Consultation Response from KC Highways
2019/91232 Tower Works, York Avenue, Fartown, Huddersfield, HD2 2QR
Change of use from car repairs garage to car sales and new 3m high fence
Date Responded: 25/07/19 Responding Officer: CNB Responding Ref: K5-9NE/12

BLOCK/SITE PLAN  
AREA 36m x 36m  
SCALE 1:200 on A4  
CENTRE COORDINATES: 414513, 418820

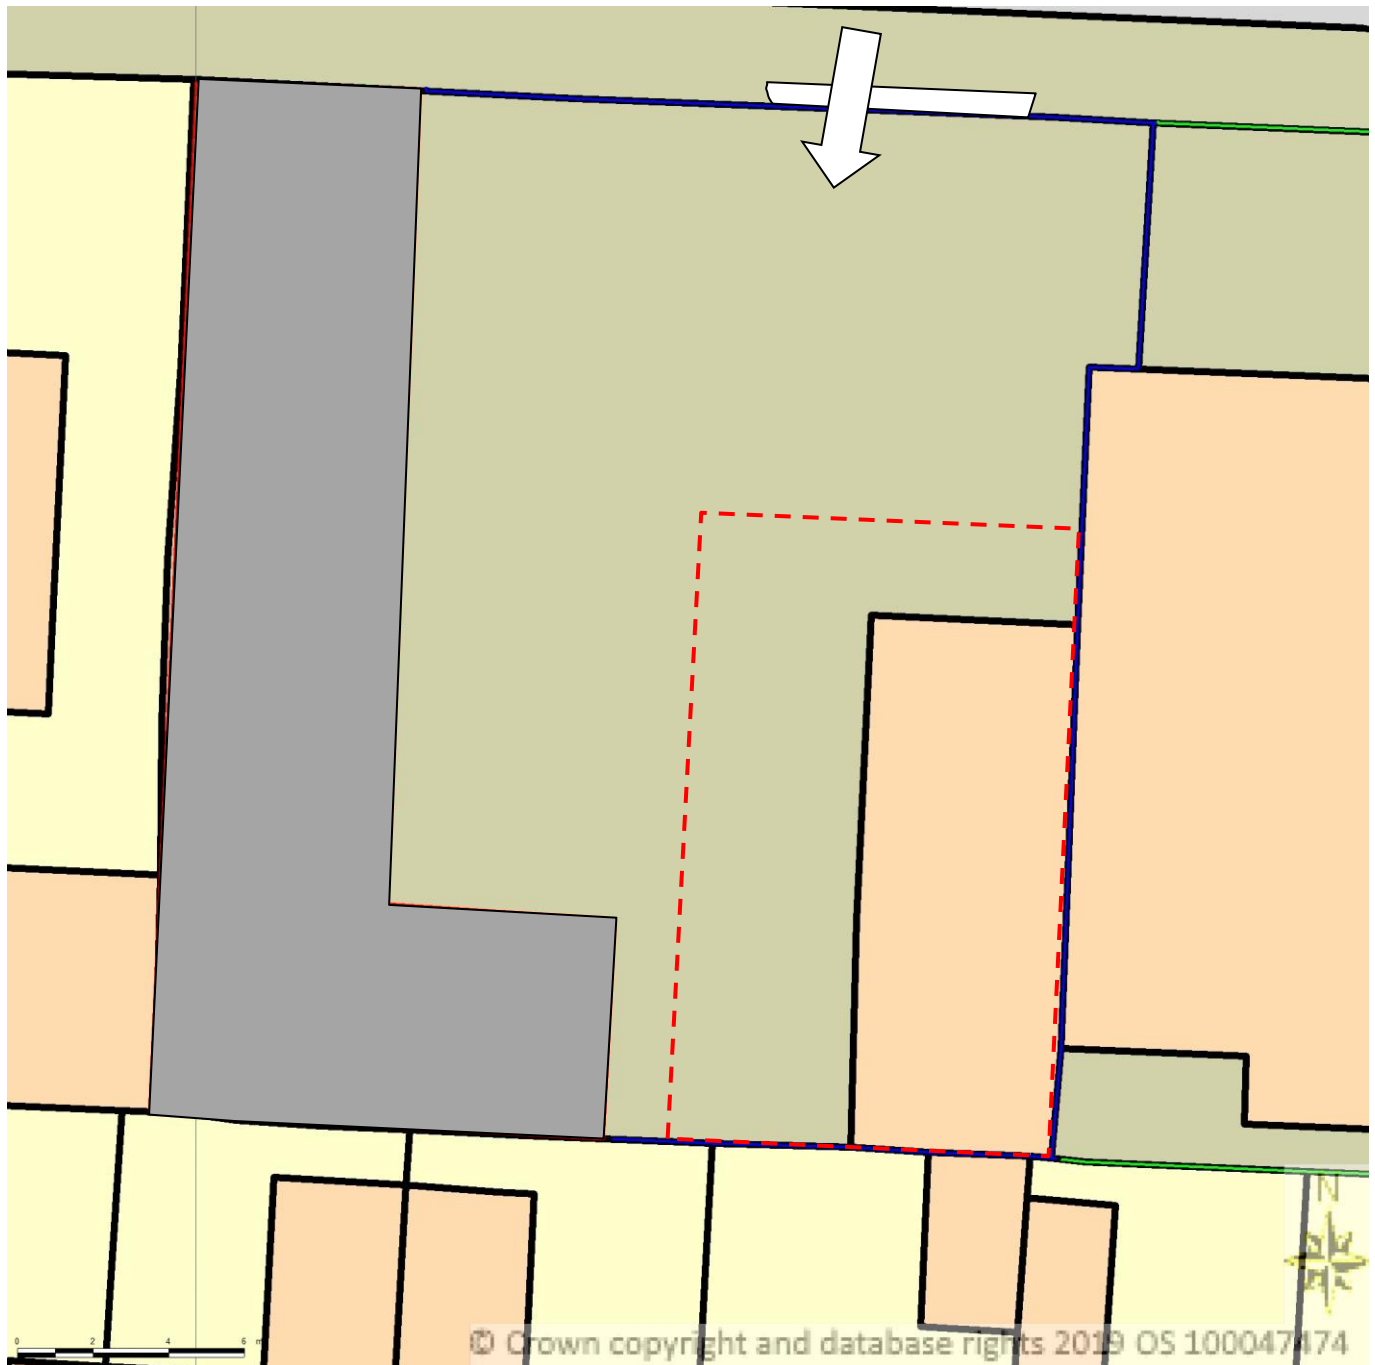
Additional information was supplied indicating the extent of the car sales area and this shows that there will be suitable space to still operate the car wash commercially if this is required (the exact use of the car wash or the car repairs was not clear at the time of writing) and also sufficient space to allow parking for car sales customers.

We would not wish to see any uses that would cause queuing on to the highway or any car sales being made from on the highway. Adequate queue management should be put in place to ensure car wash vehicles are not allowed to queue on the highway.

With this the HDM team consider that the application is now acceptable on highways grounds.
